Rezoning Transportation Analysis

Petition Number: 2019-167

Revision Log:

Date	Description
12-17-2019	First Review
01-15-2020	Second Review
05-22-2020	Third Review

| SCHEMATIC SITE PLAN | |

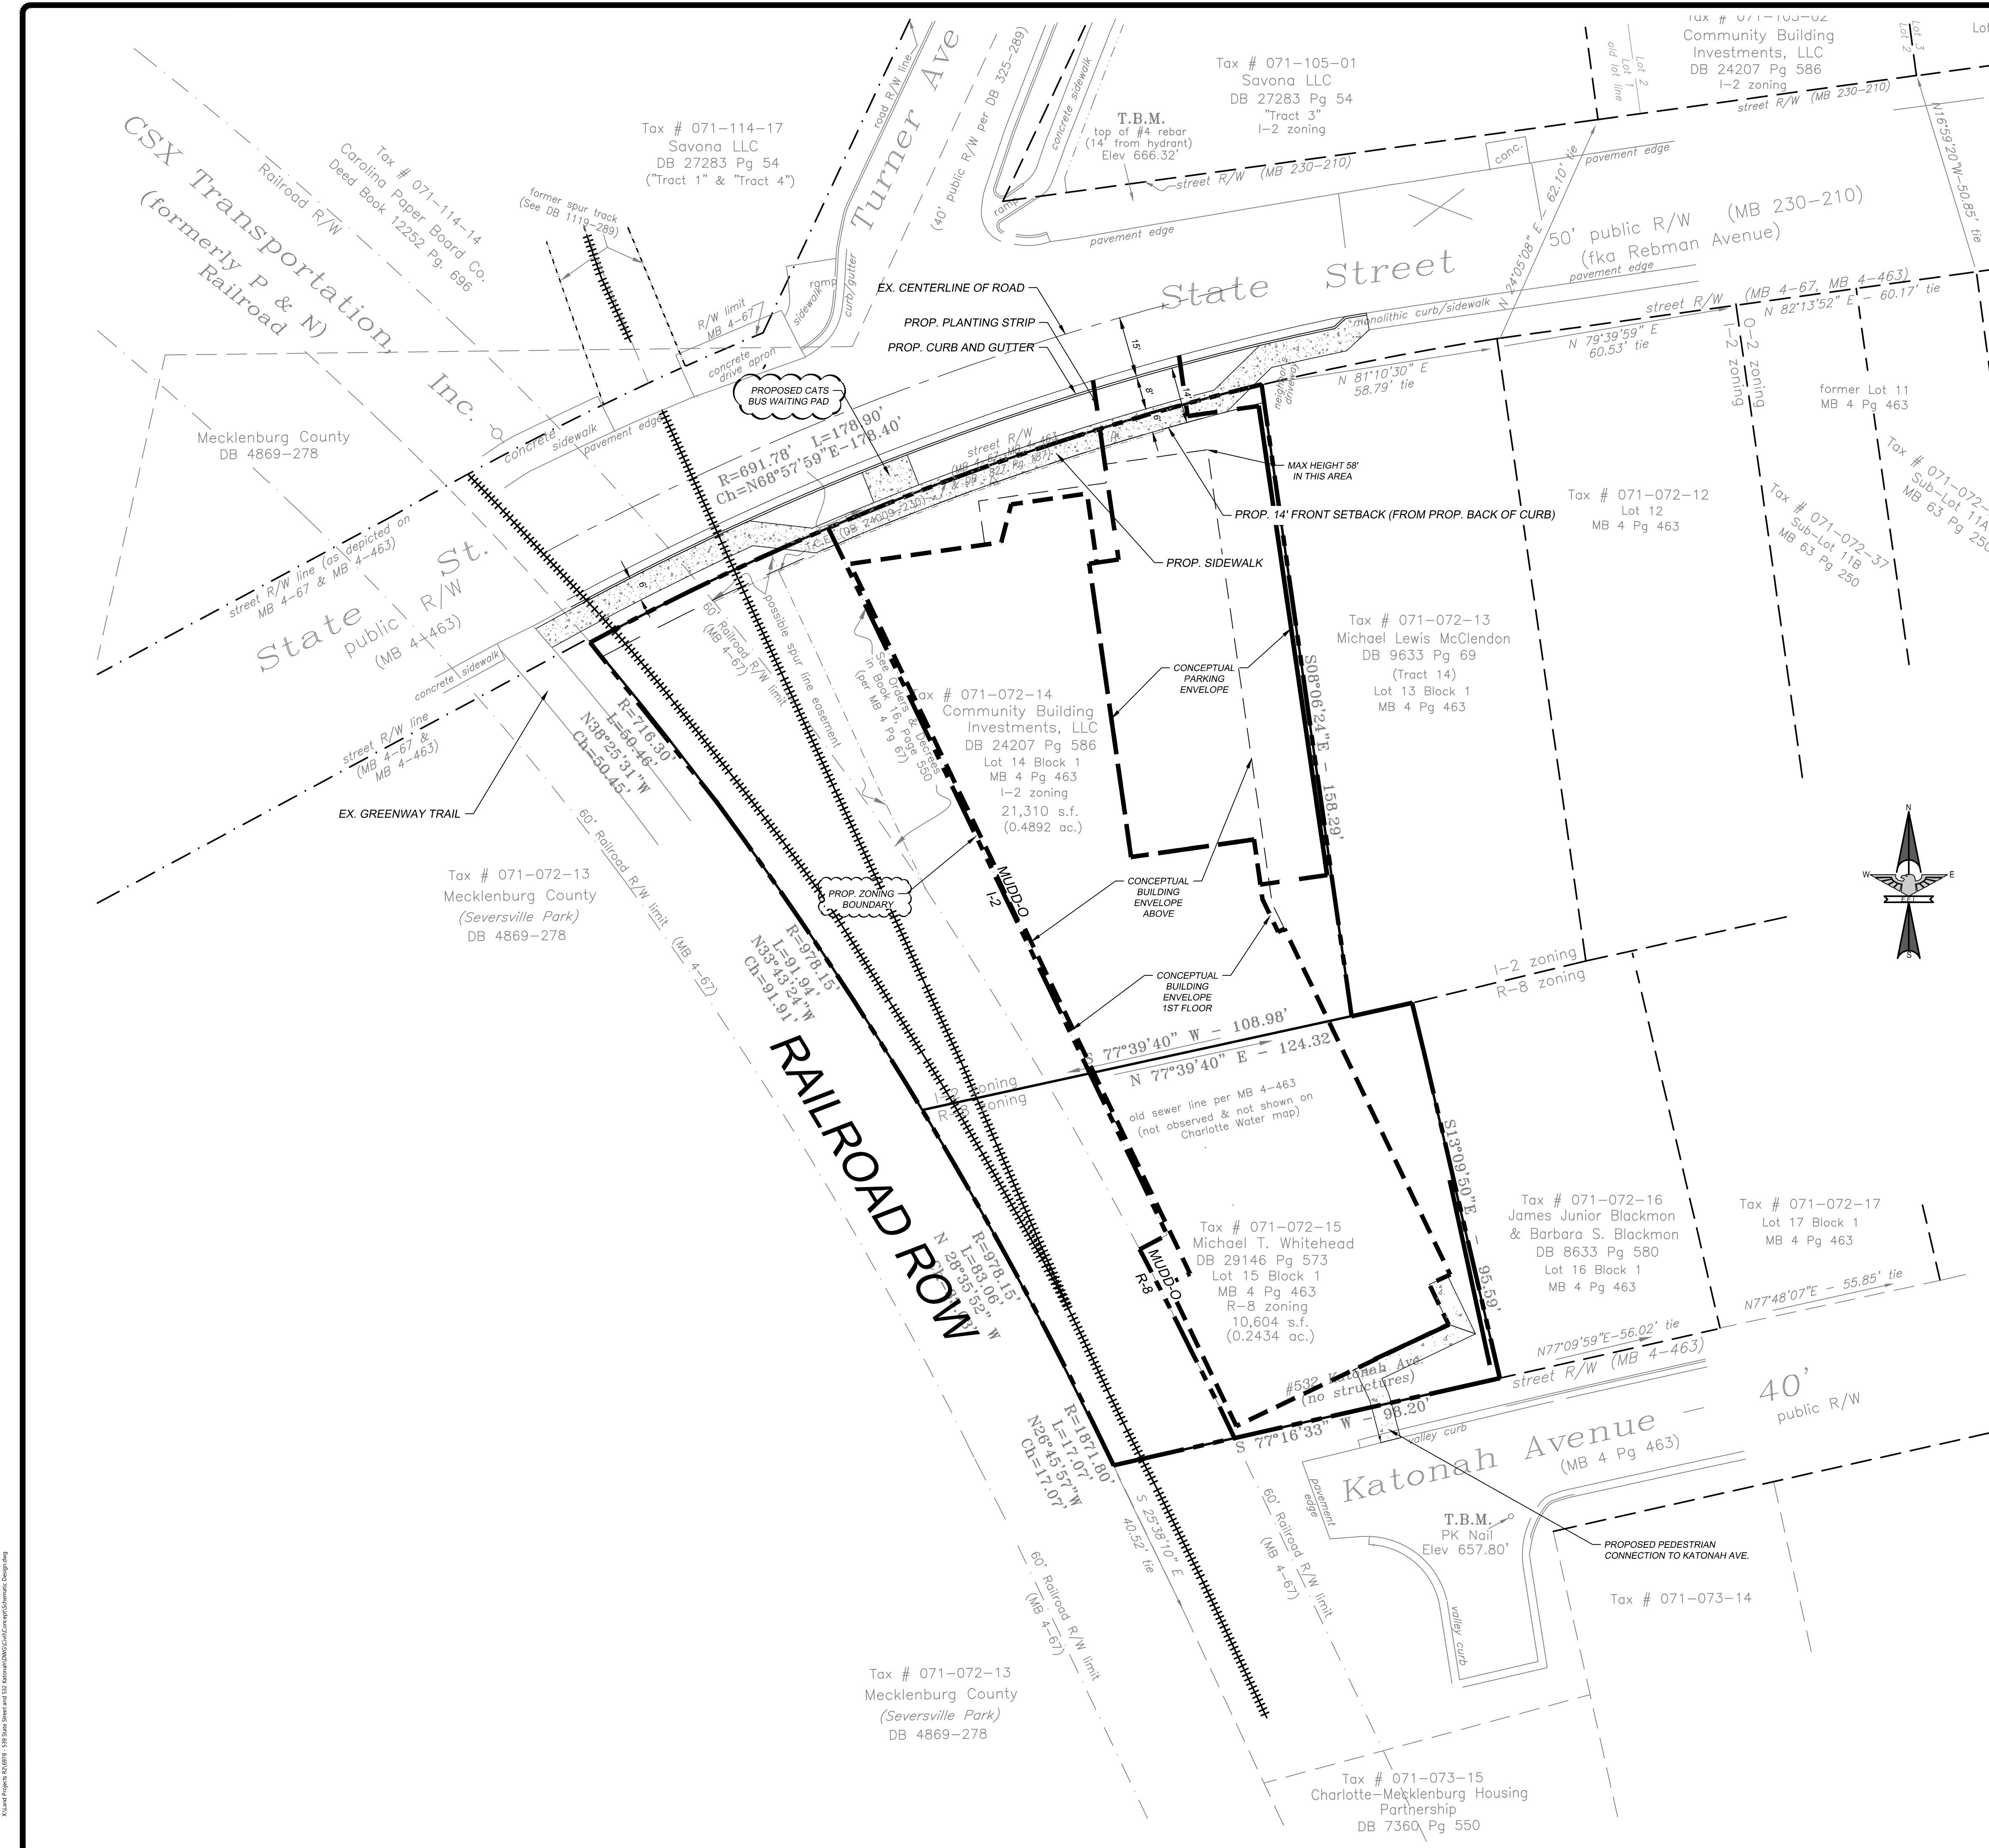
1. ~~Curbline~~ ~~The proposed zoning district has a setback measured from back of the existing or proposed future curbline.~~
 - a. ~~State Street:~~ ~~The curb and gutter should be constructed 15-foot from the centerline.~~
 - b. ~~Katonah Avenue:~~ ~~The future location of curb and gutter is in its existing location.~~

~~The site plan should show the curb and gutter labeled and dimensioned from the centerline for each road.~~
2. ~~Traffic Study~~ ~~A Traffic Impact Study is not necessary for the complete review of this petition.~~
3. ~~The proposed Urban Residential zoning requires an updated streetscape along State Street. The petitioner should update the site plan and conditional note(s) to commit to construct an 8-foot planting strip and 6-foot sidewalk, to comply with the council adopted [Charlotte WALKS](#) policy and provide connectivity to the Stewart Creek Greenway.~~
4. ~~To comply with the council adopted [Charlotte WALKS](#) policy and support the Capital Investment Plan, the petitioner should revise the site plan and conditional note(s) to commit to extend the proposed sidewalk beyond the property frontage of State Street to connect to the Stewart Creek Greenway.~~

5. ~~The petitioner should revise the site plan to provide additional details about the driveway isle and parking within the site.~~
~~**New Comment based on revised site (Site Plan 01-14-2020):** Due to the density and number of daily trips this development will generate, the petitioner should revise the site plan and conditional notes to commit to two points of ingress and egress, including access on State Street and Katonah Avenue.~~
